To: The Secretary
An Bord Pleanála
64 Marlborough St
Dublin 1
D01 V902

Re: Proposed Wind Energy Development by Ballinlee Green Energy Ltd. – Observation under Section 37E / Planning & Development Act 2000 (Case Number :PAX91.323780)

Figure 3-12: Final Site Layout

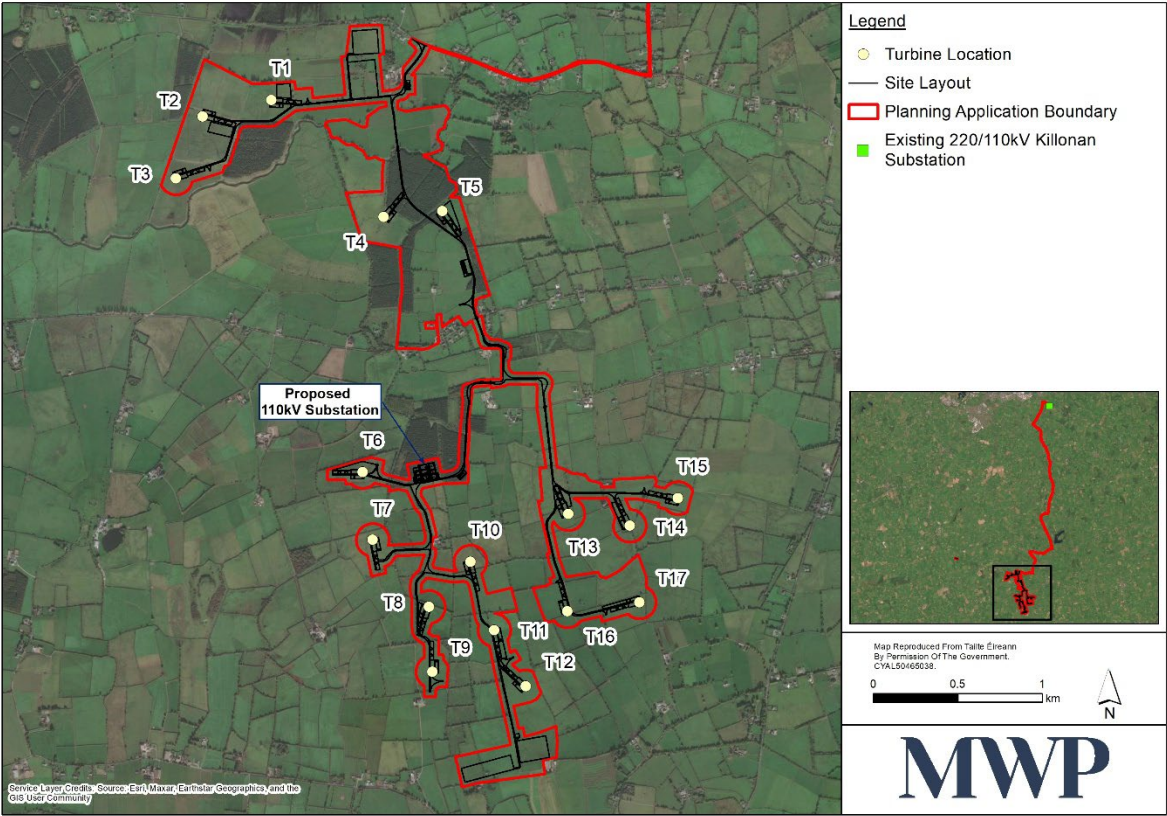
- Please assess the landscape where T1,2,and 3 are proposed as it is subject to flooding. We propose that T1,2 ad 3 do not get planning permission as this will worsen the flooding of this area. Potentially consider could they be located in an area elsewhere on that landholding

- Significant concern about the impact of excavation will have on flooding levels in our local area. Specifically, the area where wind turbines T1, T2 and T3 are proposed to be located. This area experiences regular flooding, especially during the winter months as demonstrated in the above pictures.
- The R512 from House 9 towards Bruff is subject to sinking and the road level becomes uneven very quickly due to subsidence. Road maintenance works are carried out every number of years. We feel the increased traffic at construction and maintenance phase will have a negative effect on this already vulnerable stretch of road.

Figure 15-3: Wind Turbine and Dwelling Locations

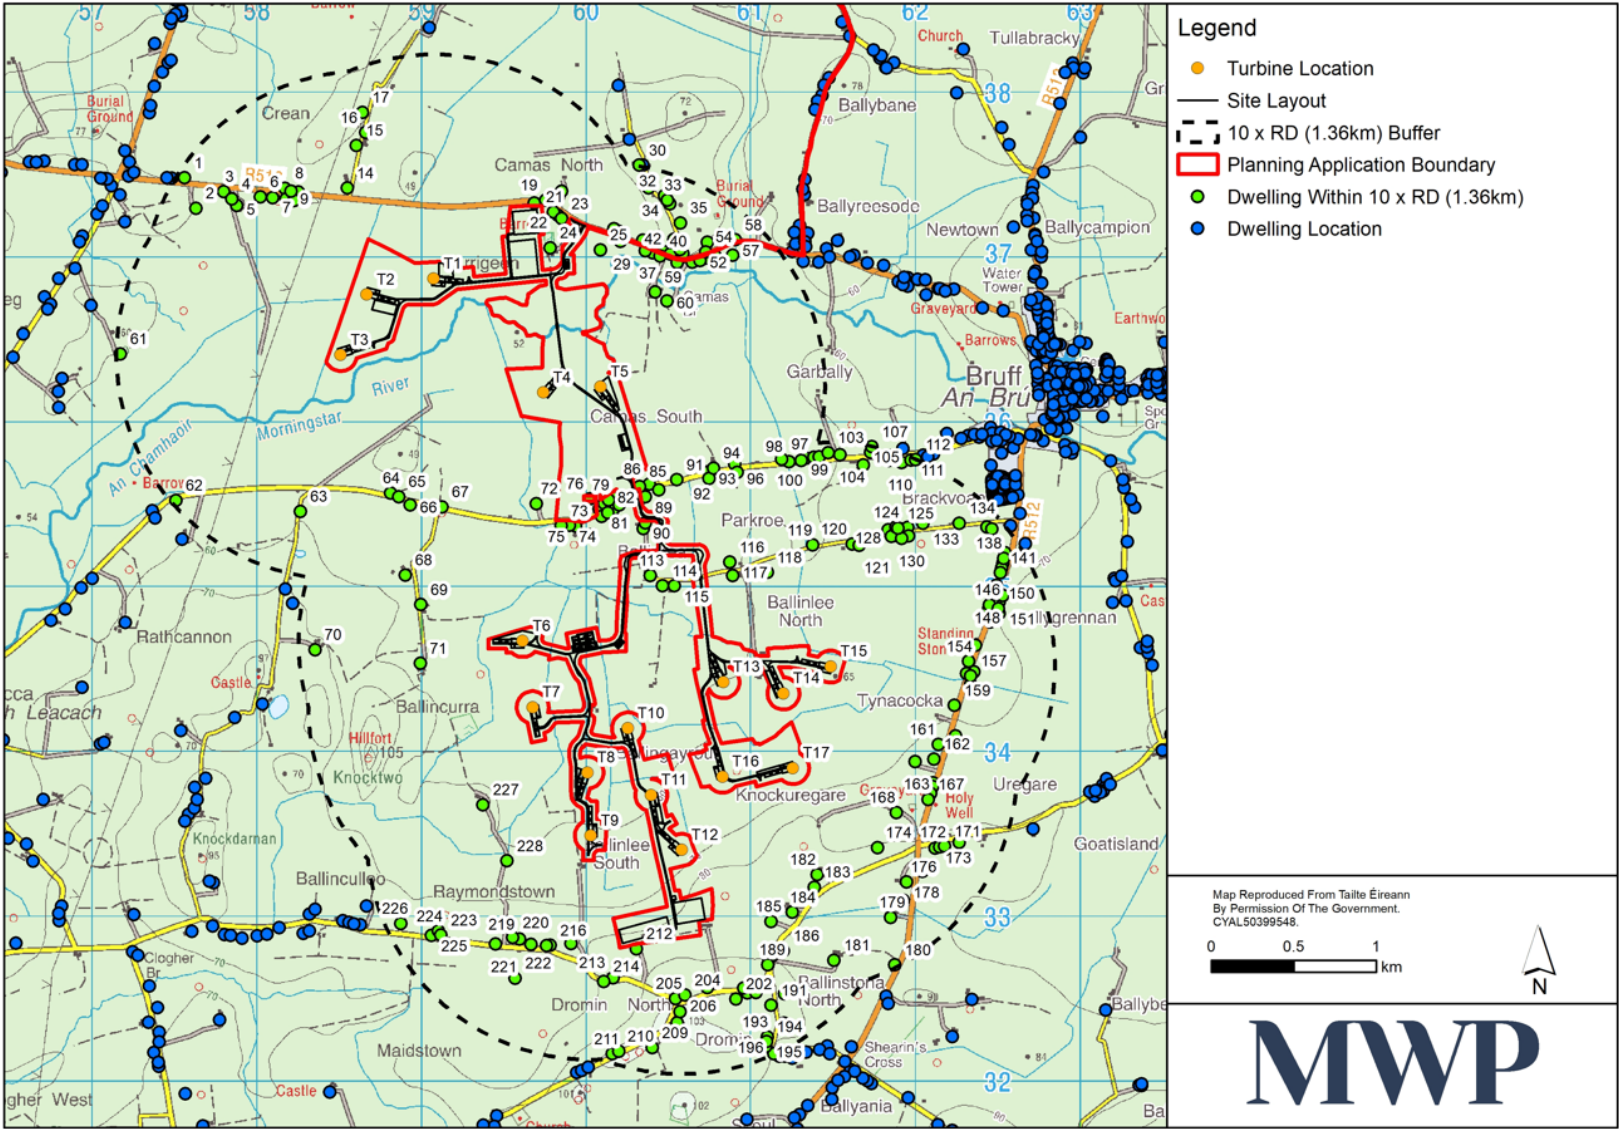
- The 2006 Wind Energy Development guidelines established that shadow-flicker at neighbouring dwellings should not exceed 30 hours per year or 30 minutes per day.

- Our house is dwelling No. 12. shown above in green.

- As you can see from the table. The maximum days per year affected might be 134 and maximum minutes per day might be 43.
- We believe that the development should not go ahead given the proposal breaches these guidelines for our property, as clearly stated in the application. If the permission goes ahead An Bord Pleanala need to make it a condition of the planning permission that the developers needs to endeavour to commit to install mitigation measures that will eliminate shadow flicker in line with the draft 2019 guidelines.

Figure 4. Projected flight lines from VP surveys illustrating SW-NE trend and the proposed enhancement area. KDE isopleth bands are used as a swan-day index for levels of site use with opacity increasing with intensity of use (1-25%, 25-50%, 50-75%, > 75%) as in Figure 3.

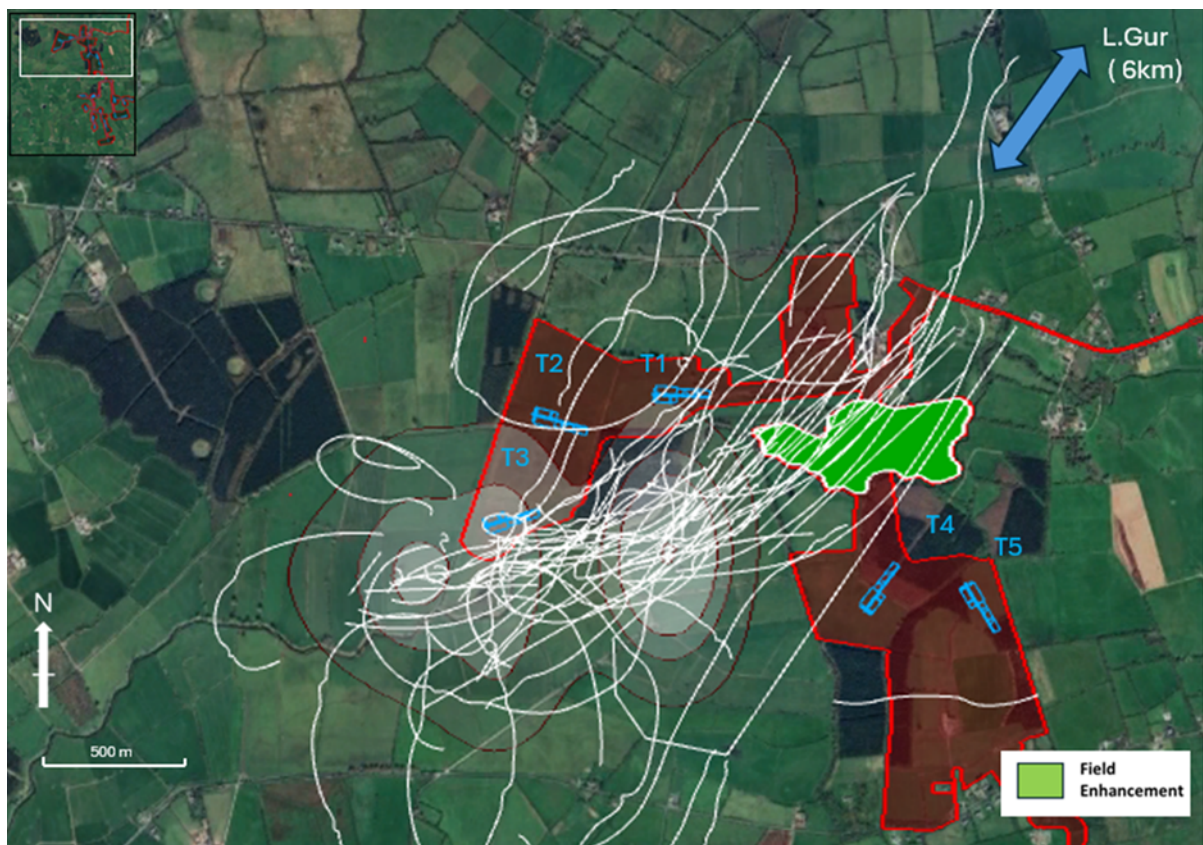
- We request that the Bord verify whether the baseline ecological surveys are sufficiently current and comprehensive (e.g., relating to bats, birds, protected flora and fauna, habitats). Any omission may undermine the reliability of the impact assessment.
- Specifically, regarding the Whooper swan which migrates here every year, we have concerns that the specified mitigating factors are not sufficient to protect this species.

- The above 2 photographs were taken on the morning of the 16/11/25. Circled in black is a single Whooper Swan flying in the direction of where T1 and T2 are to be located.
- The land where T1, T2 and T3 are located is subject to flooding every year and sometimes up to 3-6 months of the year. This draws flocks of swans, geese, herons and seagulls. We are significantly concerned about the impact this will have on those populations.
